Permit Number: 091183

This is to certify that FOGG PAMELA M & JEAN E FOGG & FOGG ITS/
has permission to Replace existing front porch
AT 28 WALL ST

November 18, 2009

I have reviewed your application to replace and expand the front porch at your house. At this time I must deny your application.

# Plot Plan

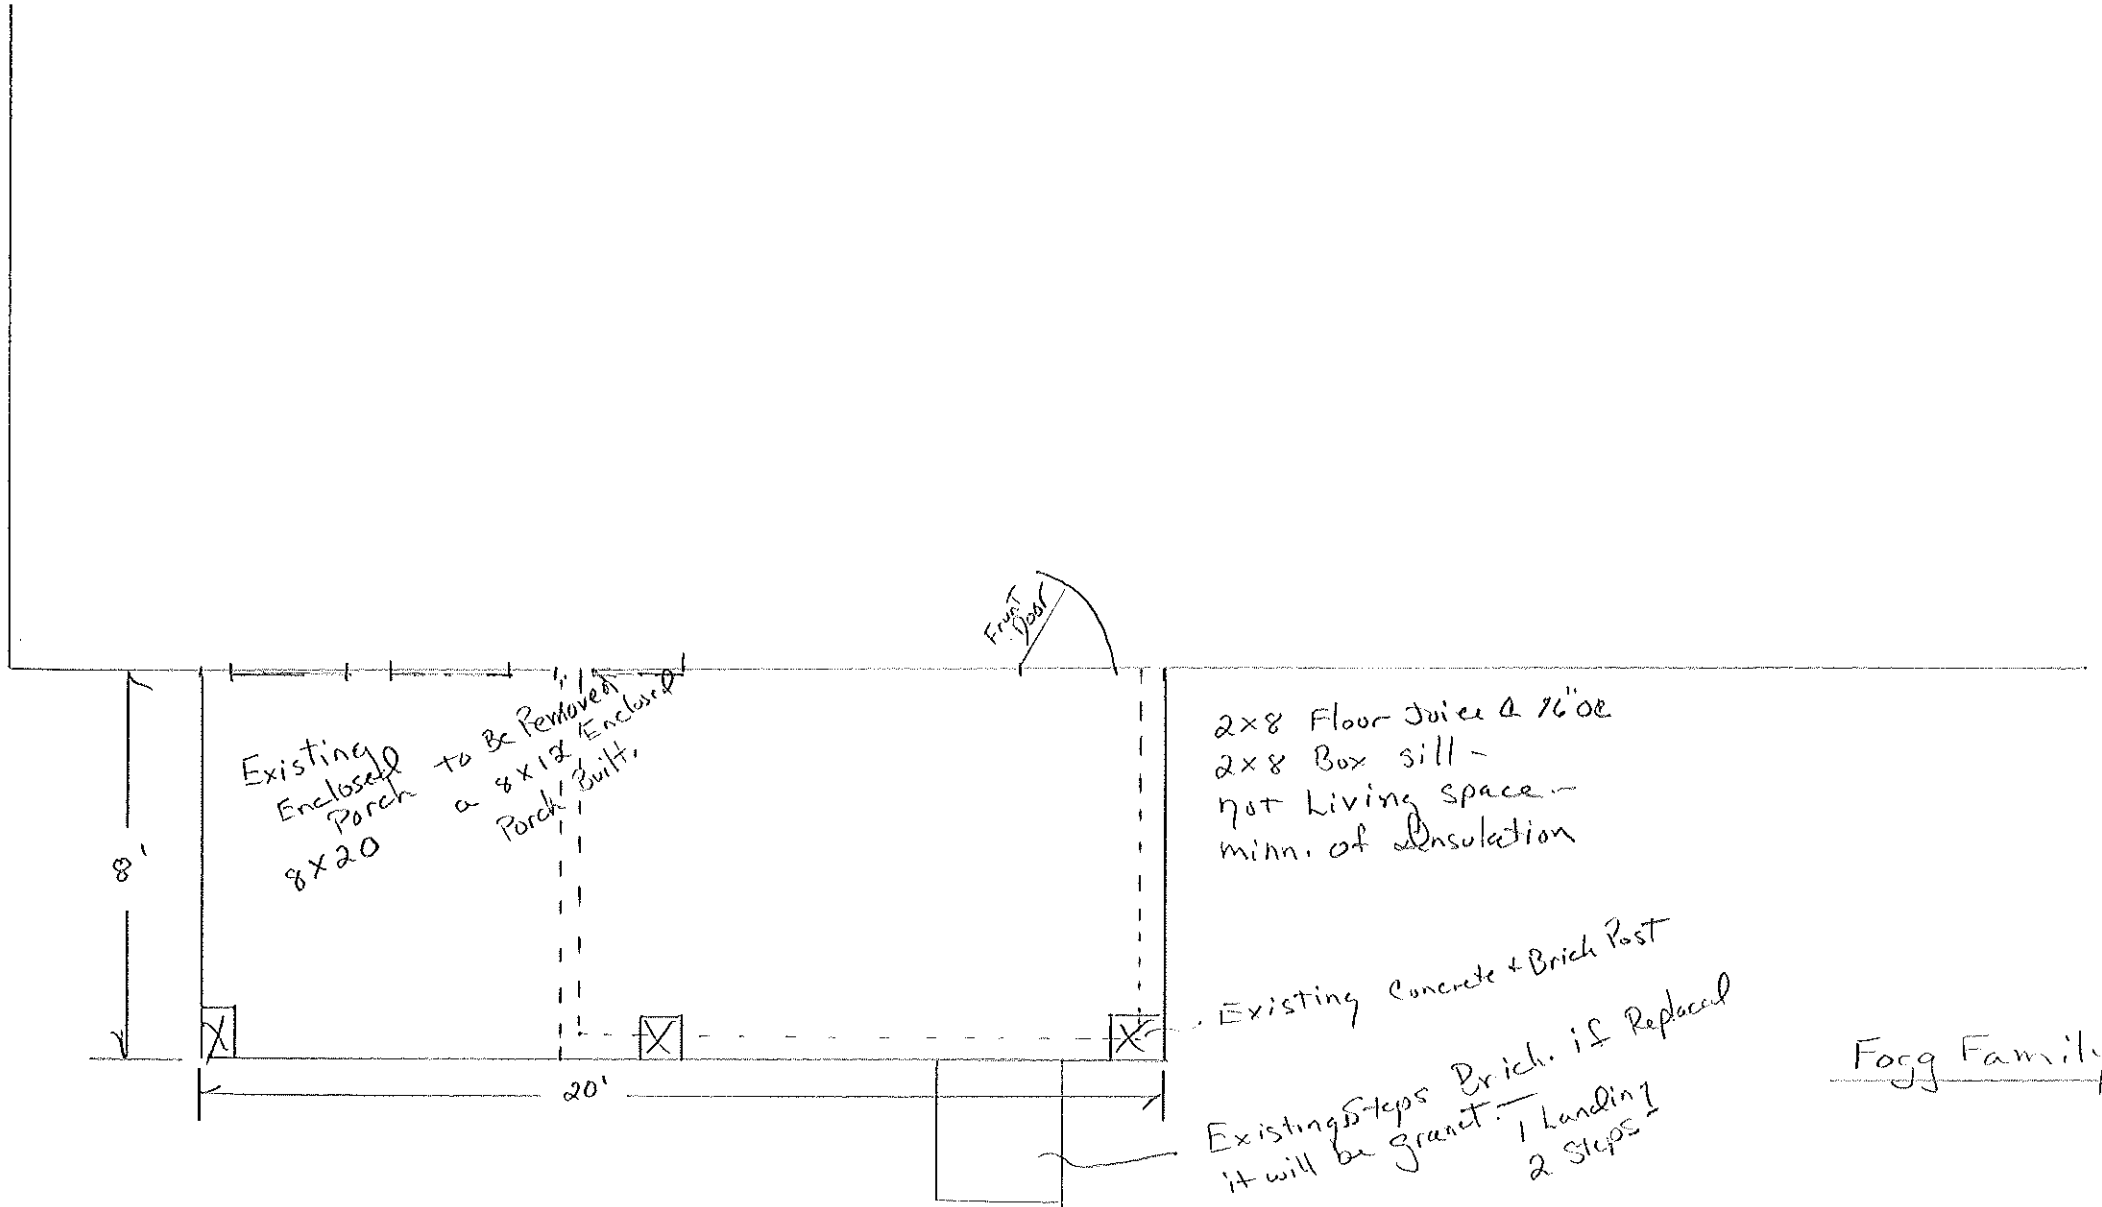
28 Wall Street is located in a R-3 residential zone. According to the plans, your existing porch is eight feet by twenty feet, four inches. Your proposed porch is eight feet by thirty-seven feet. Since you are expanding your existing porch, the expansion needs to meet the current setbacks for the R-3 zone. The required front yard setback is twenty-five feet [section 14-90(d)(1)]. The plot plan shows the front setback as fourteen feet, seven inches. Since there is not twenty-five feet from the front property line, you cannot expand your porch. You can rebuild the existing porch in the existing footprint, but you cannot expand it.
